Application for a non-material amendment following a grant of planning permission.

PROPOSED DETACHED DWELLING AND GARAGE
INCLUDING VEHICULAR ACCESS

H16-0398-11

PROPOSED ELEVATIONS - SHEET 1

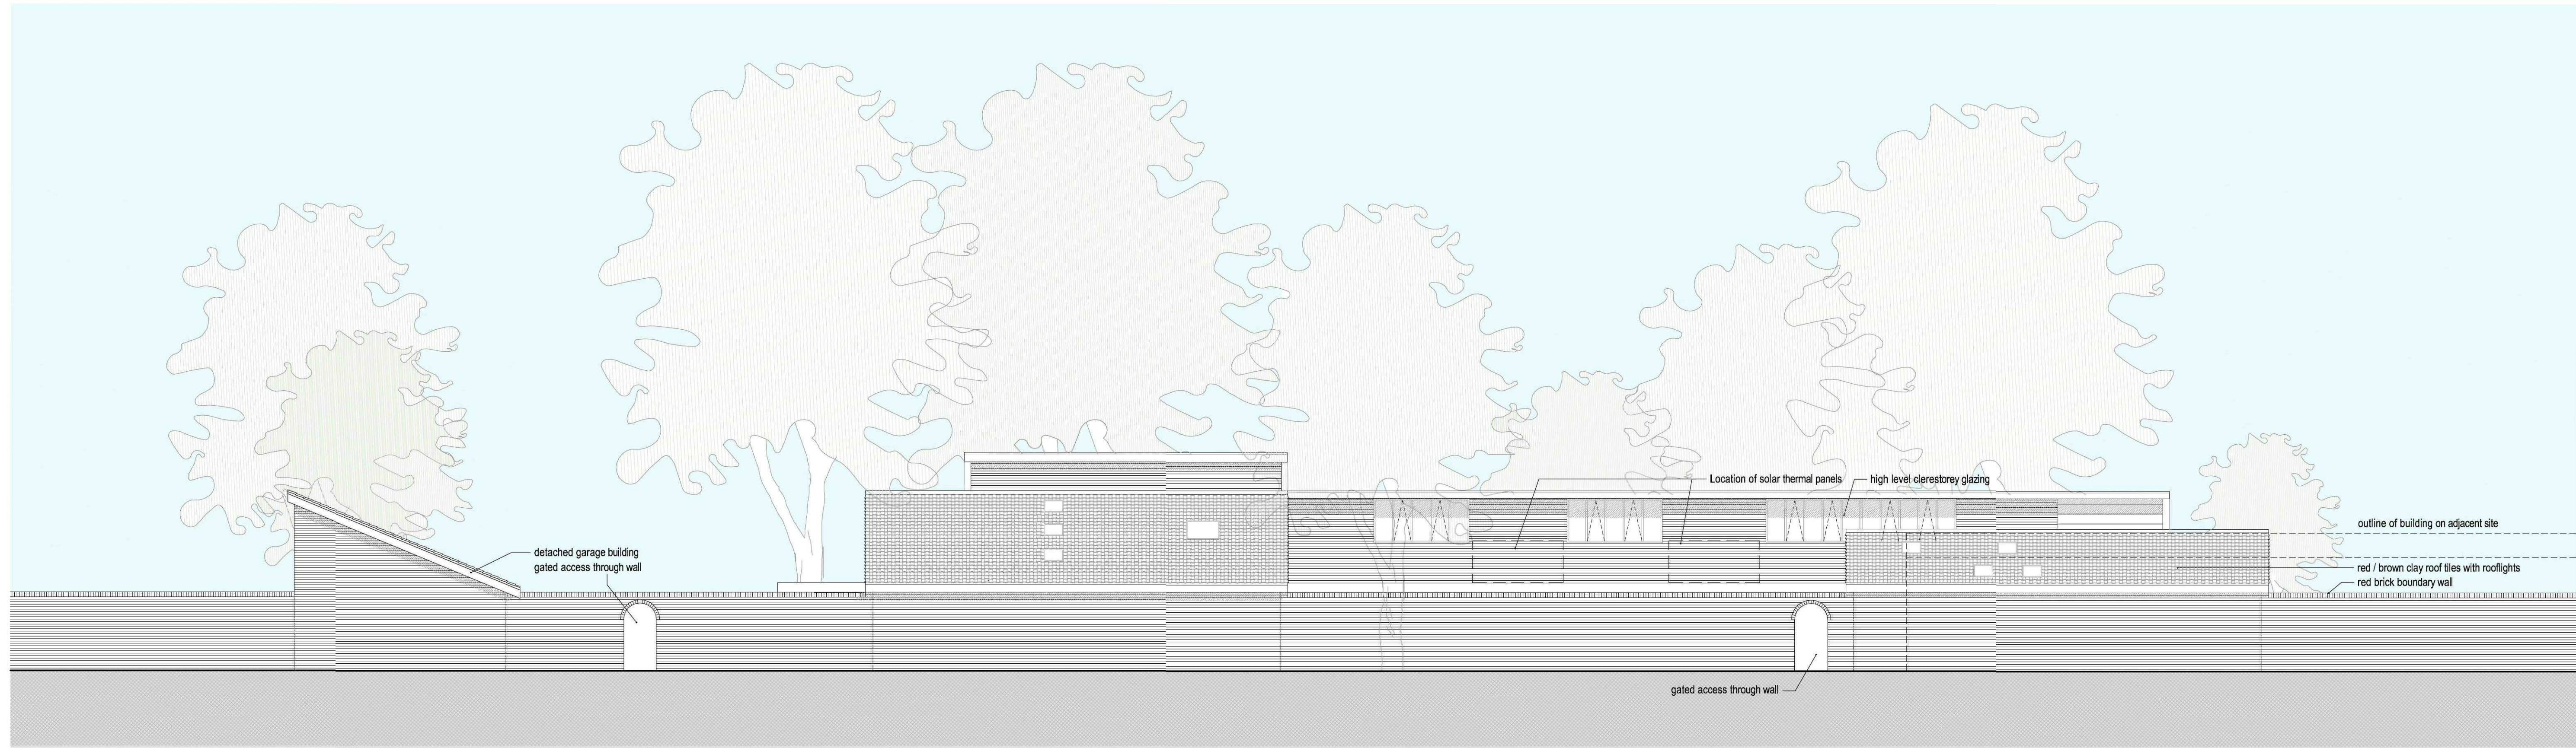
ALTERATION OF THE ELEVATIONAL TREATMENT TO THE
INNER COURTYARD. COPPER PANELS OMITTED IN LIEU
OF FACING BRICKWORK USED ELSEWHERE ON THE
BUILDING

3734/104 'D' AND 109 'C'
